Springwell Solar Farm

Responses to First Written Questions (ExQ1)

Doc. Ref. EN010149/APP/8.14
Deadline 1
June 2025
Springwell Energyfarm Ltd

REV 01

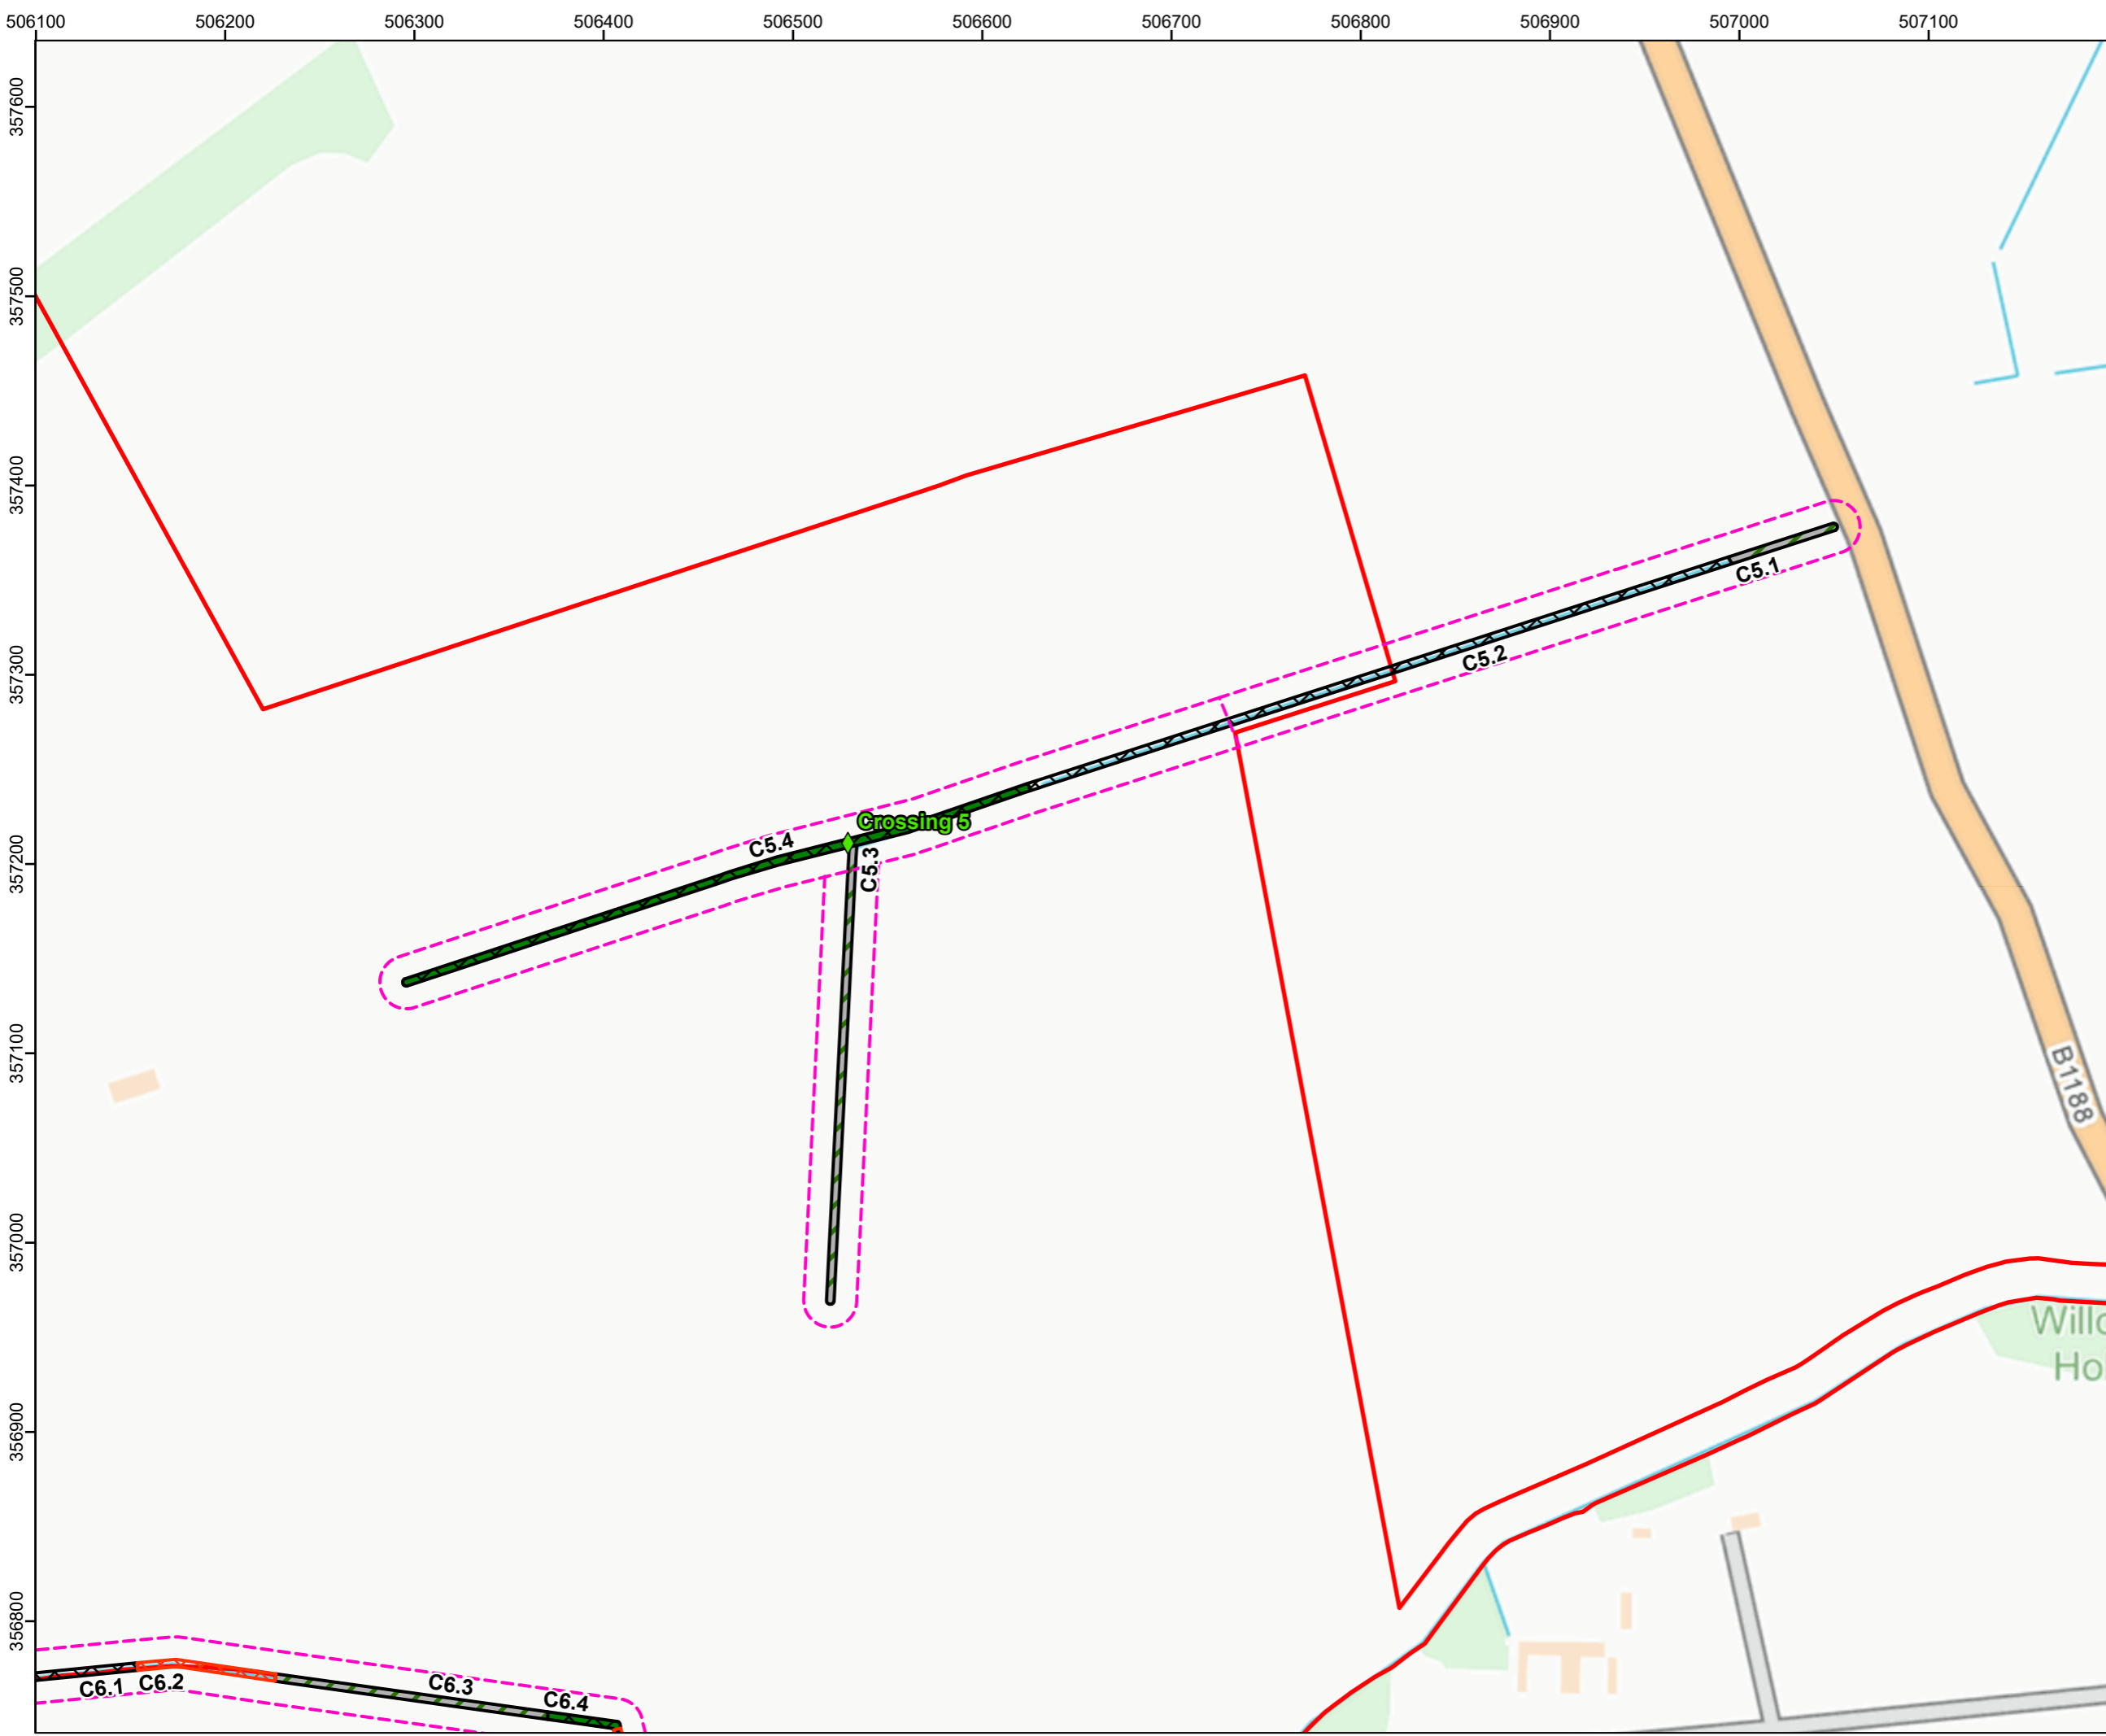
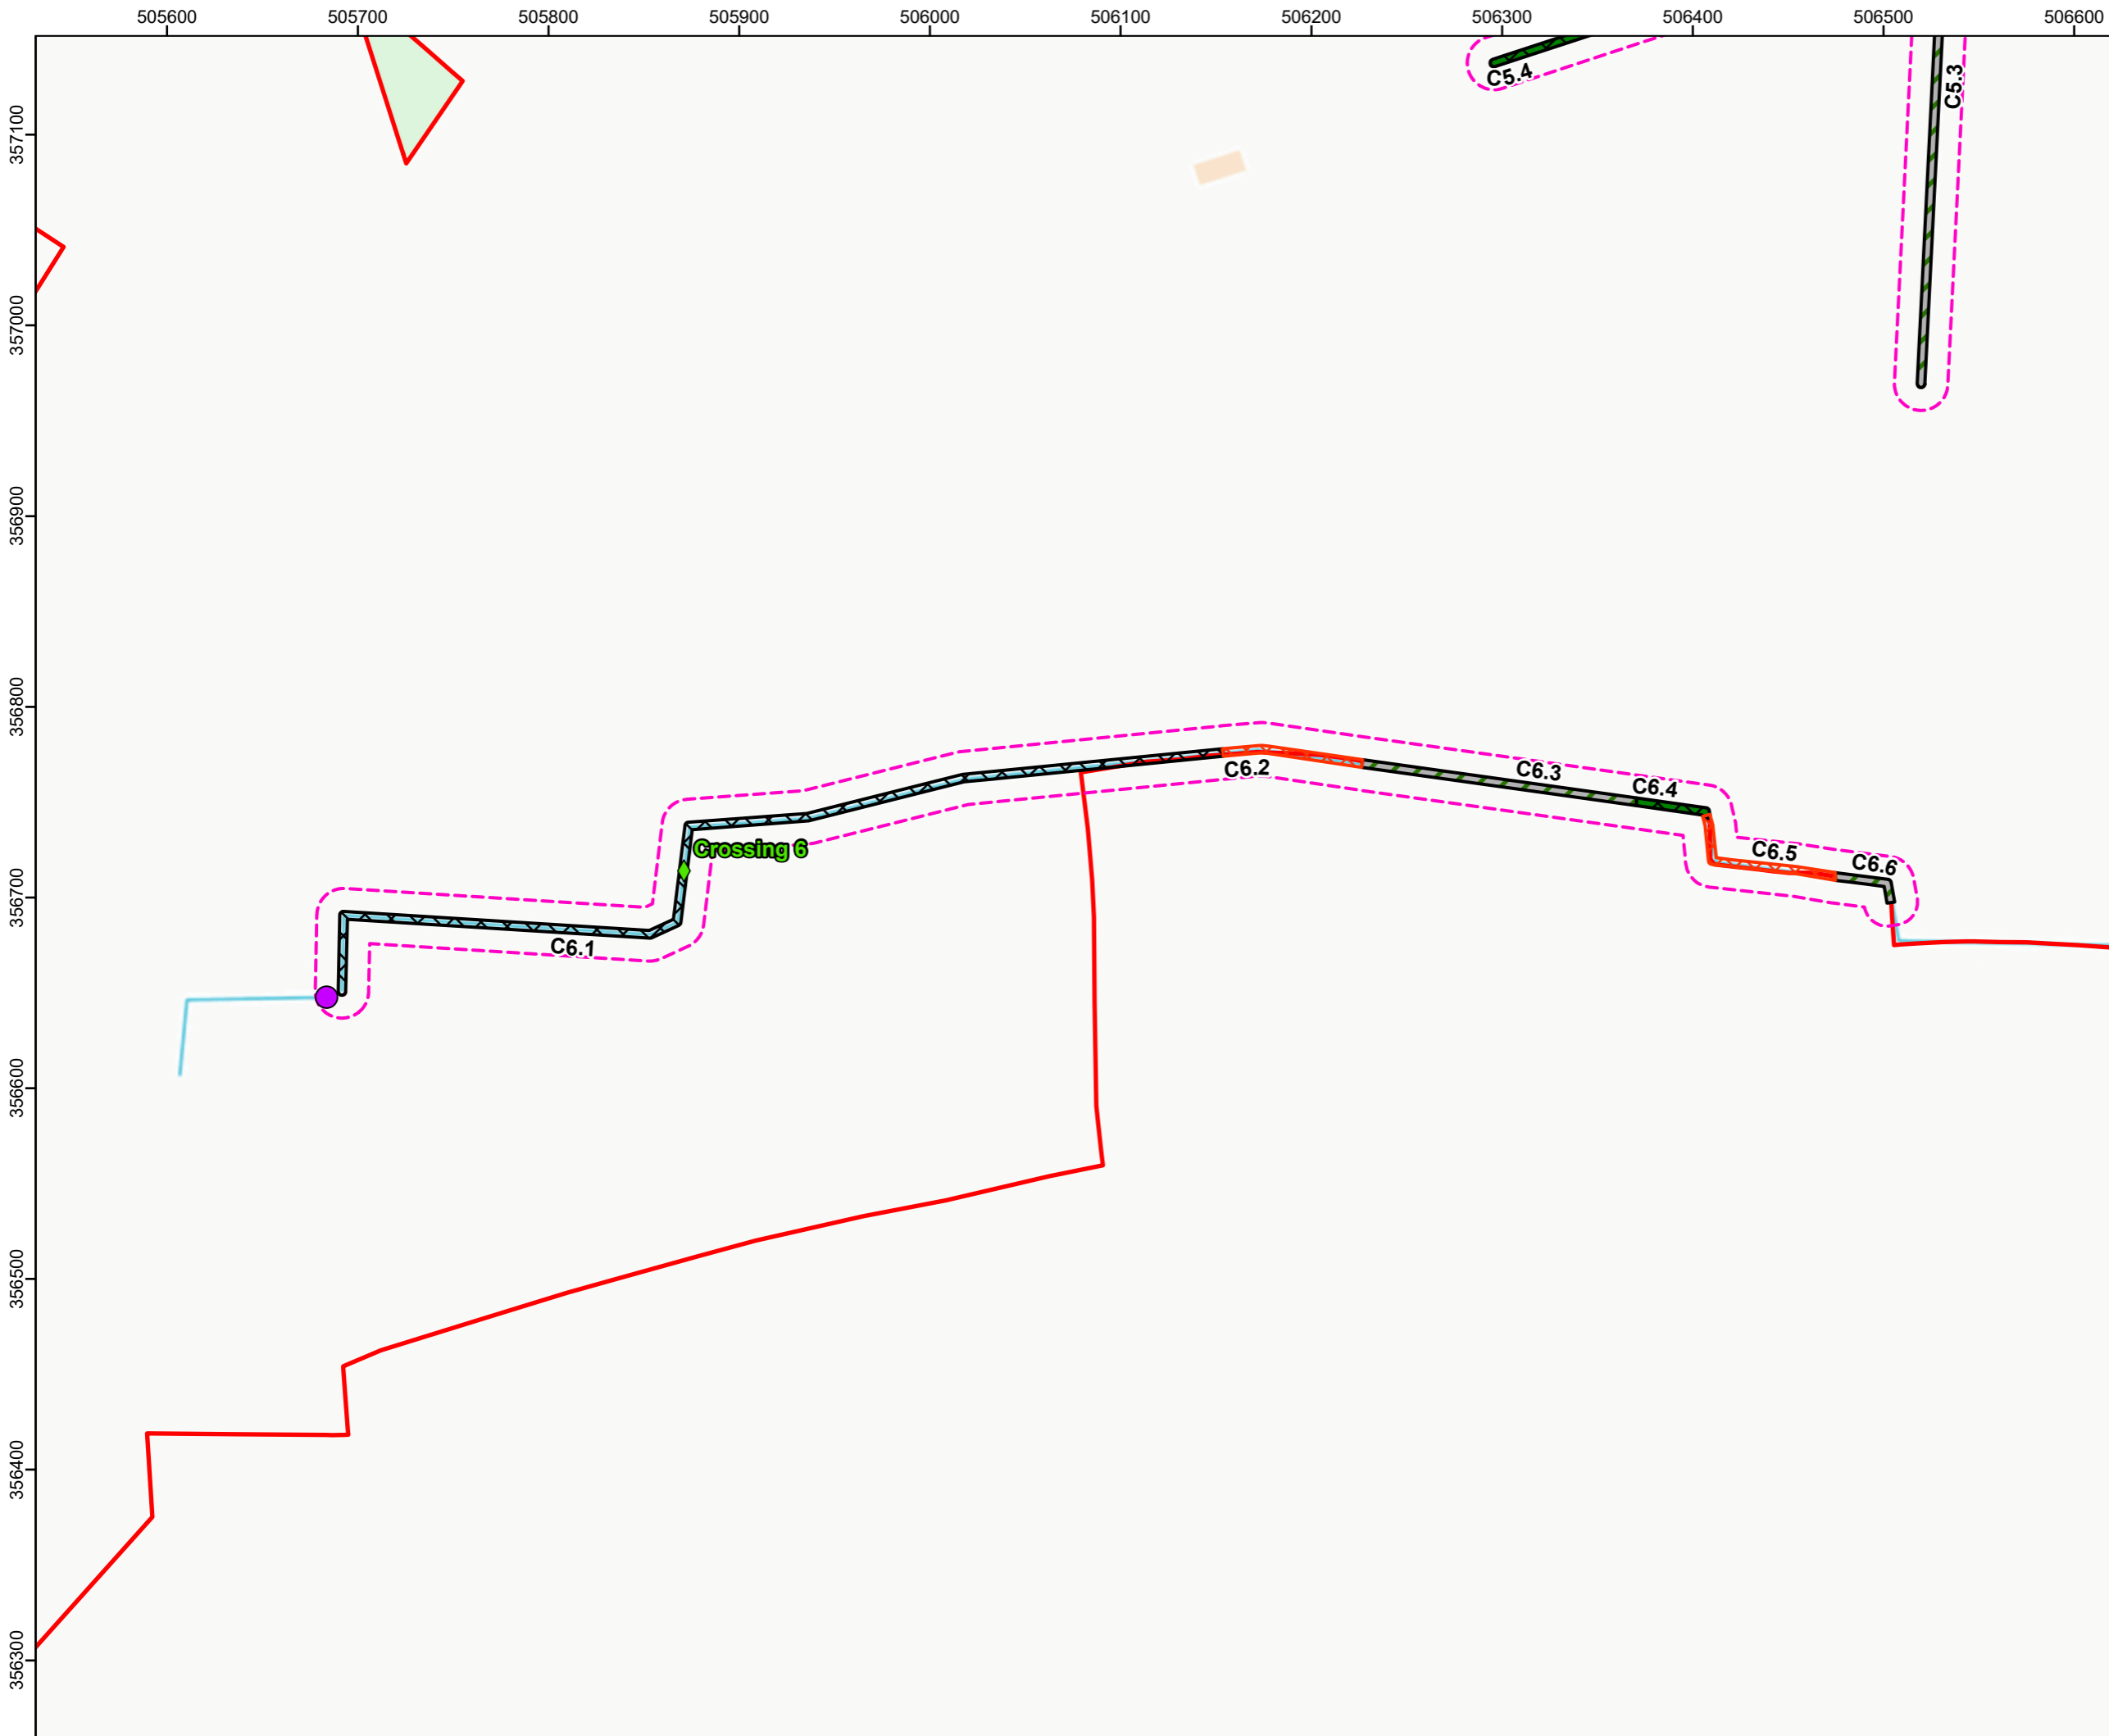
Q1.4.8	<p>Culverting of Watercourses</p> <p>Under the heading of 'Biodiversity, ecological, geological conservation and water management' NPS EN-3 states in paragraph 2.10.87 that culverting existing watercourses/ drainage ditches should be avoided.</p> <p>The ES [APP-047] states that six sections of ditches which will need culverting for internal access road bridges or are in close proximity to</p>	<p>Internal access tracks within the Site will follow the alignment of existing agricultural tracks and, following further review, there is now no requirement for new drainage ditch crossings. There are several existing ditch crossings across the Site which are proposed to be used to facilitate access across the Proposed Development. A further review of ditch crossings has been undertaken and this is detailed below within Table 1 and should be read in conjunction with ES Volume 3, Figure 3.15: Indicative Watercourse and Ditch Crossings [EN010149/APP/6.2.2] [APP-060]. These commitments are secured within the oCEMP [EN010149/APP/7.7.2] which has been updated at Deadline 1.</p> <p>Crossing Point</p>

ExQ1 Ref	Question	Applicant Response
	proposed works. The Riparian Mammal and Aquatic Habitat Assessment Survey [APP-088] concluded that use of the surveyed ditches as temporary refuge and foraging habitat cannot be entirely discounted. In accordance with paragraph 2.10.88 of NPS EN-3, demonstrate that no reasonable alternatives exist to the culverting of these ditches?	<p>1 (located in the south west corner of Field By28)</p> <p>There is an existing culvert and farm track in this location which would be used to facilitate access. The ditch crossings would have a condition survey completed prior to any works taking place. Where there are assets, e.g. existing culverts, any required repairs, remediation or replacement would take place in accordance with the oCEMP [EN010149/APP/7.7.2] , which has been amended at Deadline 1.</p> <p>2 (located in the north west corner of Field Lf02)</p> <p>There is an existing culvert and farm track in this location which would be used to facilitate access. The ditch crossings would have a condition survey completed prior to any works taking place. Where there are assets, e.g. existing culverts, any required repairs, remediation or replacement would take place in accordance with the oCEMP [EN010149/APP/7.7.2], which has been amended at Deadline 1.</p> <p>3a and 3b (located in the northern corner of Field Bk10)</p> <p>There is an existing culvert and farm track in this location which would be used to facilitate access. The ditch crossings would have a condition survey completed prior to any works taking place. Where there are assets, e.g. existing culverts, any required repairs, remediation or replacement</p>

ExQ1 Ref	Question	Applicant Response
		would take place in accordance with the oCEMP [EN010149/APP/7.7.2] , which has been amended at Deadline 1.
		4 (located in the southern corner of Field Bk04) There is a reasonable alternative for access to this location and therefore, this ditch will not be culverted. This is secured within the oCEMP [EN010149/APP/7.7.2] , which has been amended at Deadline 1.
Q1.4.9	<p>Protected Species Licences</p> <p>The ES states [APP-047, Paragraphs 7.8.11 and 7.9.24] that any loss of bat roosts would be mitigated and compensated under a European Protected Species licence from Natural England (NE). NE [RR-291] state that it is unable to provide a position on the likelihood of a licence being granted without having reviewed a draft licence application.</p> <p>Is it proposed that a draft licence application will be made to NE within the timescales of the examination?</p>	<p>On the basis of surveys carried out and the scheme design as discussed below, it is considered low risk that a European Protected species licence would be required, bats being the only European protected species for which one might be required, as justified below.</p> <p>Surveys of woodlands, adjacent to where hedgerows and trees will be directly affected, indicates that the woodlands are not suitable for significant bat roosts (as trees lack suitable features). Also, the bat activity data does not indicate any significant bat roosts near to where hedgerows are to be removed for highways access as no bat calls were recorded shortly after their anticipated emergence times.</p> <p>Also, the scheme design has avoided removal of trees identified with significant potential to support roosting bats, based on the ground level roost assessments undertaken. Any trees that do require removal are only likely to have up to low potential to support roosting bats – these would be subject to survey (either climbing or emergence) before felling and in the unlikely event that bats are found a licence would be applied for and mitigation agreed with Natural England. As the trees are considered of negligible or low bat roosting potential no significant roosts are anticipated to be affected. It is important to note that there is no benefit in doing climbing or emergence surveys now of trees with low bat roost potential as bat usage of tree roosts is transitory, i.e. they often switch roosts on a daily basis, and we would therefore have to re-do the survey work immediately before construction.</p>
